Our Ref: **22/03658/PREAPP**

Thank you for your pre-application enquiry received 6th December 2022 with regard to proposals at Windrush, Austin Road, Bodicote. The proposals comprise a two bedroom annexe over a previously approved double garage; extension to connect double garage to bungalow.

South Elevation
1:100

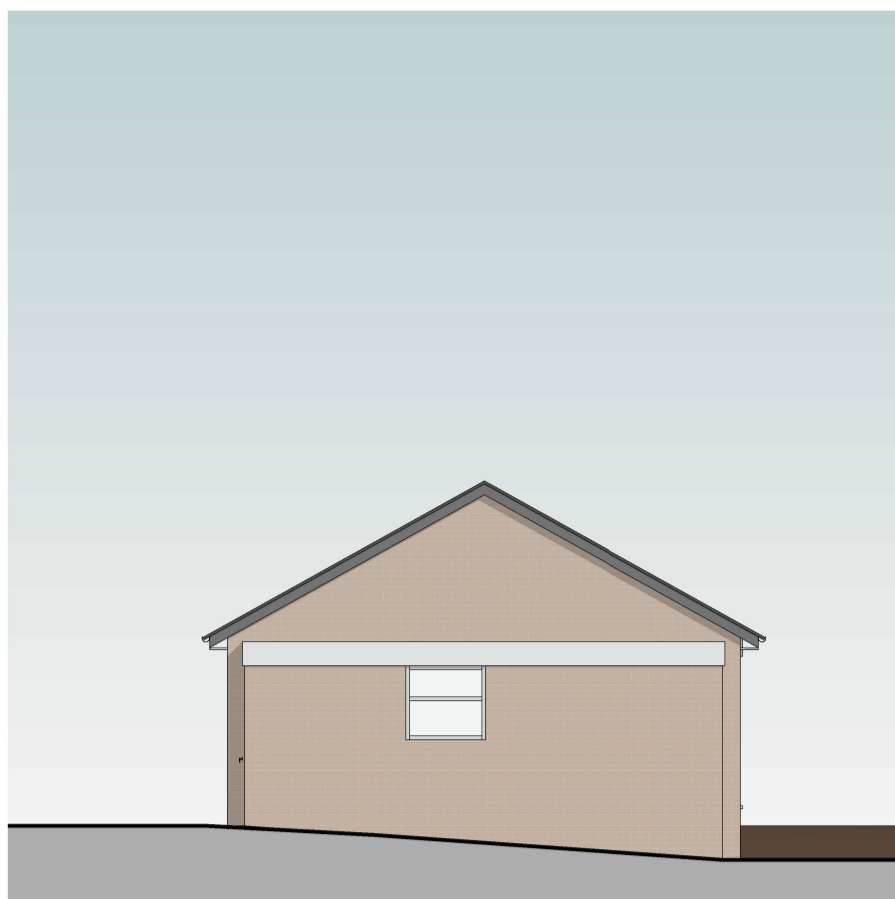
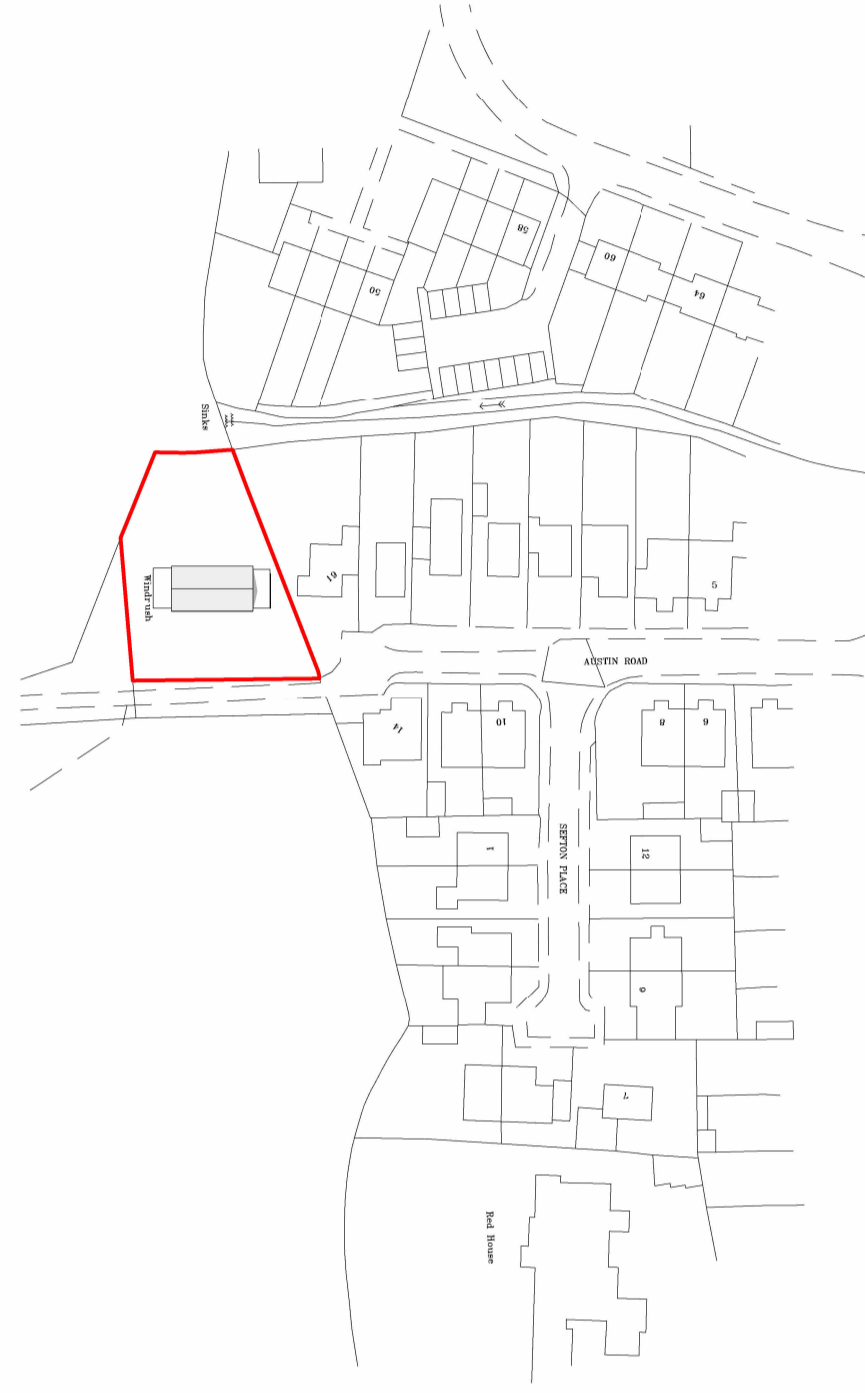
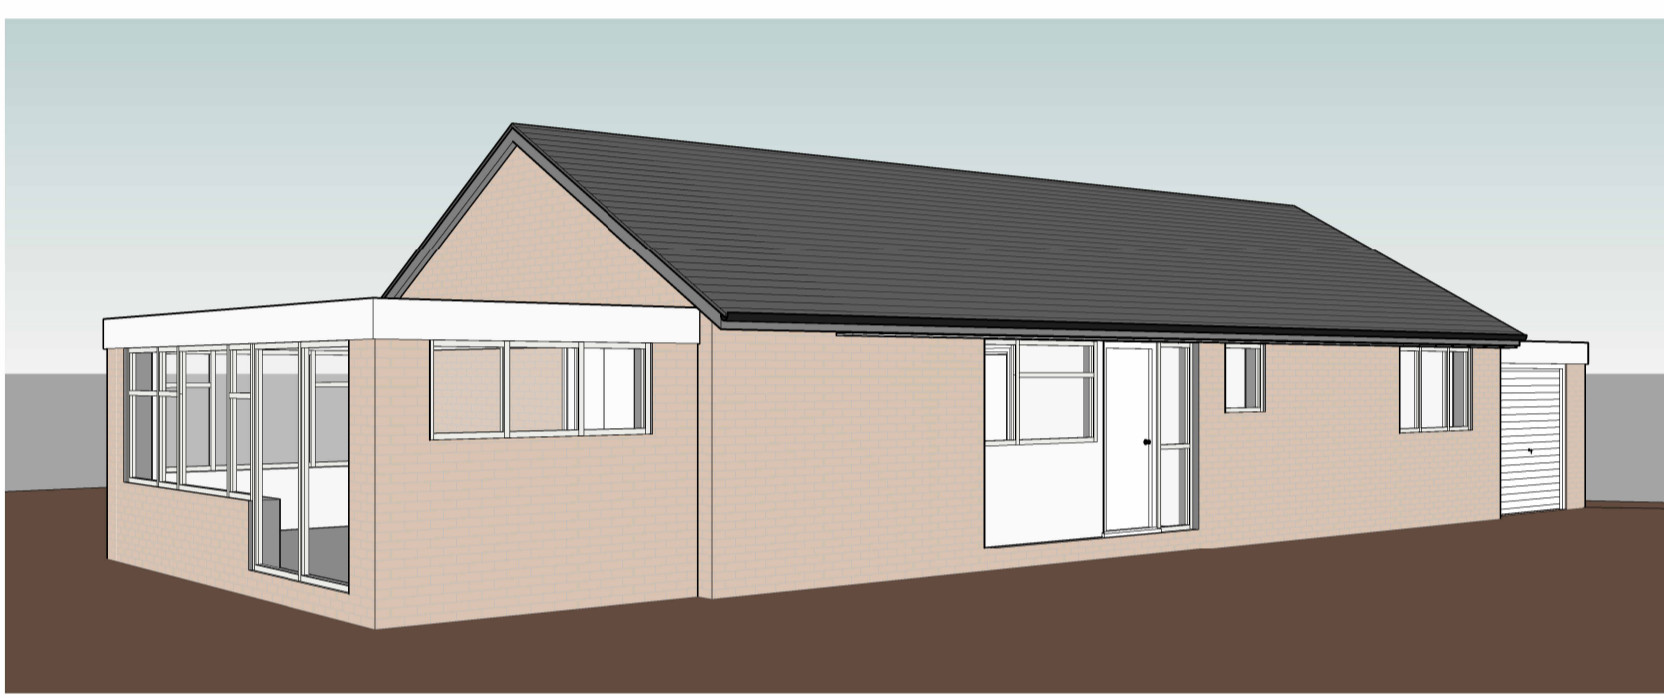
The proposed two storey development relates poorly to the character of the existing bungalow. The bulk and massing is larger than that of the bungalow, along with the extra height, which would dwarf the appearance of the original dwelling. The proposed two storey extension results in an excessive bulk and massing, which is out of character with the original bungalow.

As currently proposed the development would appear incongruous and would have a detrimental impact to visual amenity, emphasised by its visibility from the public realm and its edge-of-village location, and would likely appear imposing to the Public Right of Way (PROW) along the site's eastern boundary.

The two storey extension proposes half-dormer style roofs. This roof form is out of character with the surrounding area, which comprises bungalows and two storey properties. It is noted the site is set back from Austin Road, and partially screened by vegetation at No. 19, although the vegetation is not guaranteed to be permanent, so cannot be relied upon to make development acceptable, and the proposal must therefore be assessed on its merits.

The proposal includes render for the whole built form associated with the site. It is noted the previous approval accepted a rendered extension and a rendered garage, but that the main house would remain as brick. We have some concerns with the proposed materials, in particular the use of cladding, and the use of a mix of materials. We would encourage the use of brick as the primary facing material for the development but whether it is brick or render there would need to be one primary facing material and then perhaps occasional detailing could be in a secondary material.

If not redeveloping the bungalow as per our comments above, we would advise that the previously approved garage would be the maximum bulk and massing achieved in that position, due to the relation with the main bungalow and the impact on the visual amenity of the surrounding area.
